CITY OF ALBUQUERQUE

March 22, 2019

RE: **323 Jefferson Apartments**
323 Jefferson SE
Grading Plan Stamp Date: 2/28/19
Hydrology File: K17D116

Based on the submittal received on 3/6/19 the above-referenced Grading Plan cannot be approved for Building Permit until the following are corrected:

GRADING & DRAINAGE PLAN

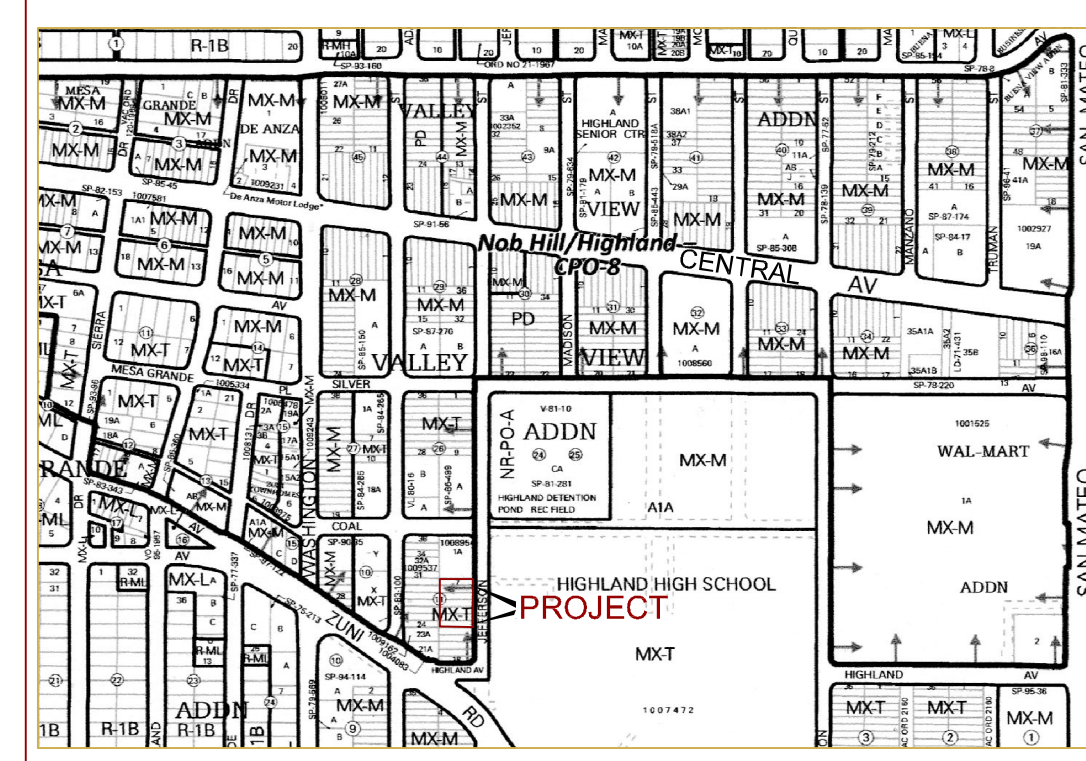
1. Provide a section through the west property line showing the grades on both sides of the property line and existing wall. Provide existing and proposed spot elevations along the property line. No additional fill may be placed against the existing wall.

2. Show the 100-yr Water Surface Elevation and the Storm Water Quality WSE. Ensure 1' freeboard is maintained along the south and west property lines, determined from the Q100 WSE. Because the sidewalk culvert invert is at 42.6' the Storm Water Quality WSE is 42.6', not 42.3'.

3. Provide a section through the pond and south property line and adjoining building. Special care needs to be taken here to ensure no water or saturated soil ponds against the adjacent building. A buried, waterproofed retaining wall/floodwall is likely needed to keep from damaging the adjacent building and get the pond to overflow to Jefferson via the sidewalk culvert. A cutoff wall with no footer is not acceptable, the retaining wall needs to be designed for saturated conditions and provided in the resubmittal. The type of waterproofing material must be specified.

4. Provide hydraulic calculations for the sidewalk culvert (primary outfall), sized for the 100-yr peak inflow; provide pond volume and routing calculations for the Stormwater Quality Volume and 100-yr storm. The weir equation with coefficient "C" =3 for a broad-crested weir must be used, not the orifice equation.

5. The pond will also need an emergency overflow sized for the 100-yr peak inflow, or you could provide 2x capacity on the sidewalk culverts. The driveway transition slab cannot encroach on the sidewalk culverts. Use the current SO-19 notes, as found on the Hydrology website.
